## Memorandum

To Chris Ritchie  
cc. Derek Mullins  
From Lilia Donkova, Technical Specialist (Hazards)  
Major Project Assessment  
Phone: (02) 9228 6110 Fax: (02) 9228 6169 Email: lilia.donkova@planning.nsw.gov.au  
Date 3 December 2012 File no File PHA review.doc

**Subject: Super Retail Group Distribution Centre, Lenore Drive, Erskine Park: Hazards and Risks**

Figure 4-4 : Heat Radiation Contours for Scenario 1: Worst Case Class 2.1 DG Fire (assuming no fire controls)

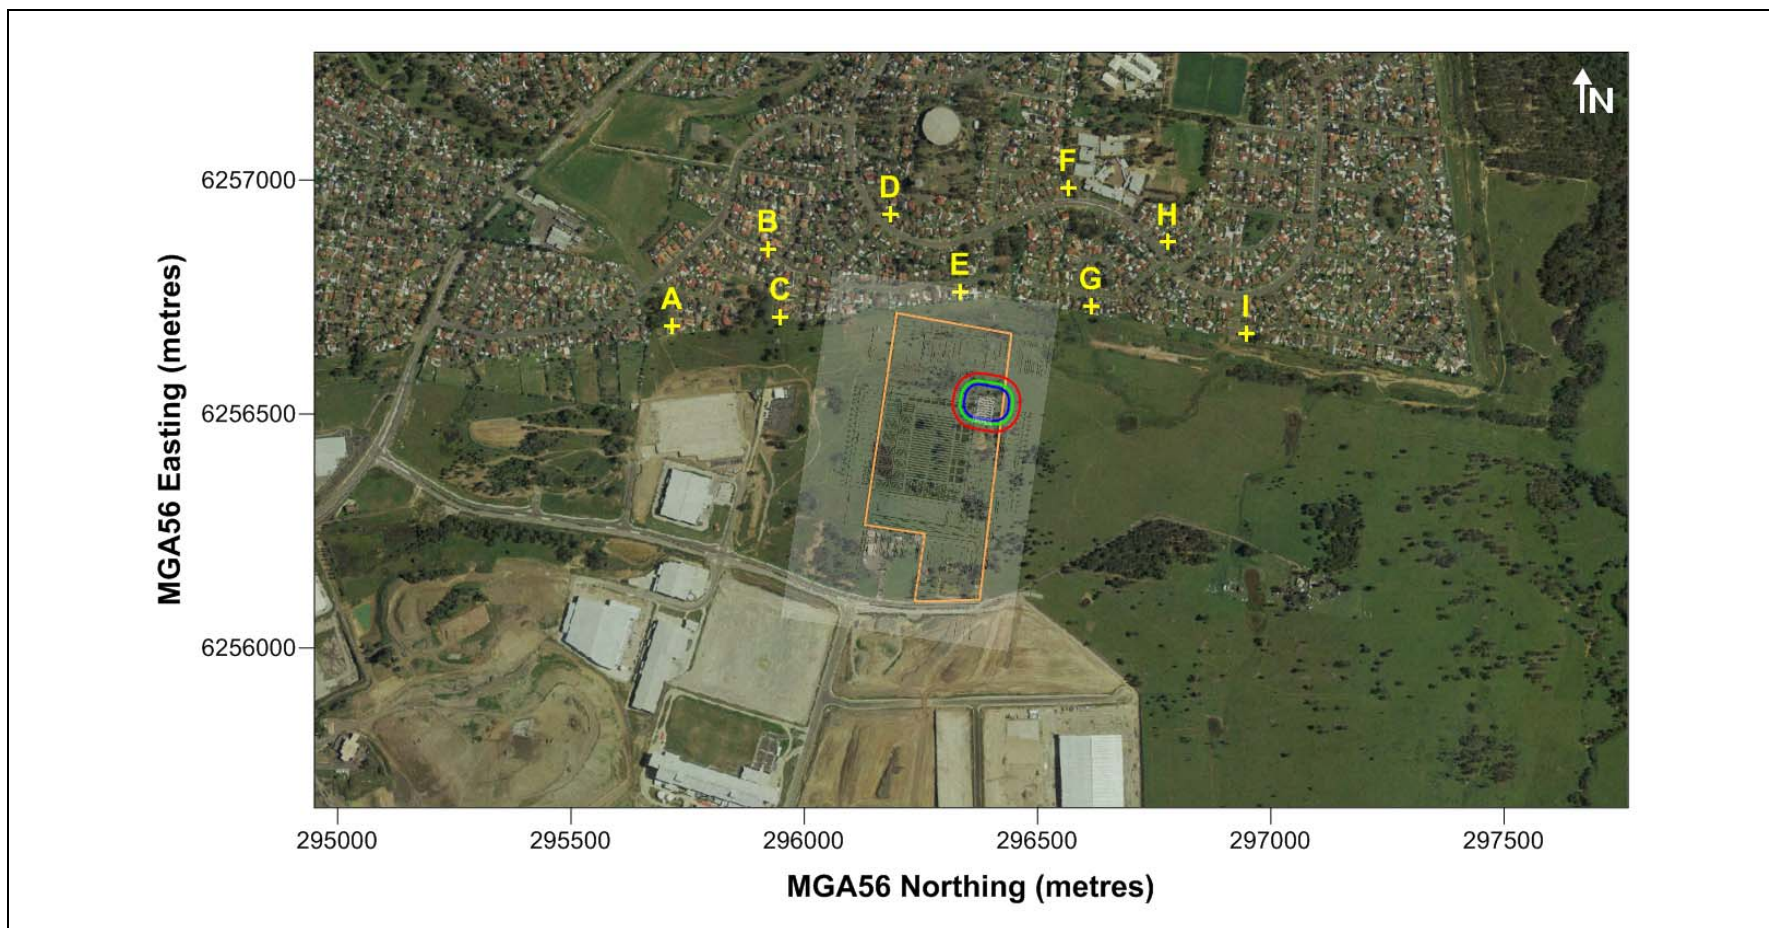
It is noted that a release of Class 2.1 materials is modelled as pool fire, although a release of pressurised flammable gas is more likely to result in a flash fire. Even though the hazard identification identifies "Fireball radiation in Class 2.1 storage area" this event is disregarded from further analysis due to proposed control and prevention measures.

- It should be noted that flash fire accidents have occurred in the past in warehouses storing aerosols ([http://www.thenorthernecho.co.uk/news/8621887.Crews\\_tackled\\_200ft\\_flames/](http://www.thenorthernecho.co.uk/news/8621887.Crews_tackled_200ft_flames/)). The Department considers that the consequences of a flash fire should be estimated and if found to have off-site effect, should be taken to the next level of analysis. The issue of escalation of the event within the aerosol area caused by multiple cans being involved in a fire (for example due to radiant heat from a fire in the flammable liquids area) should be also addressed.
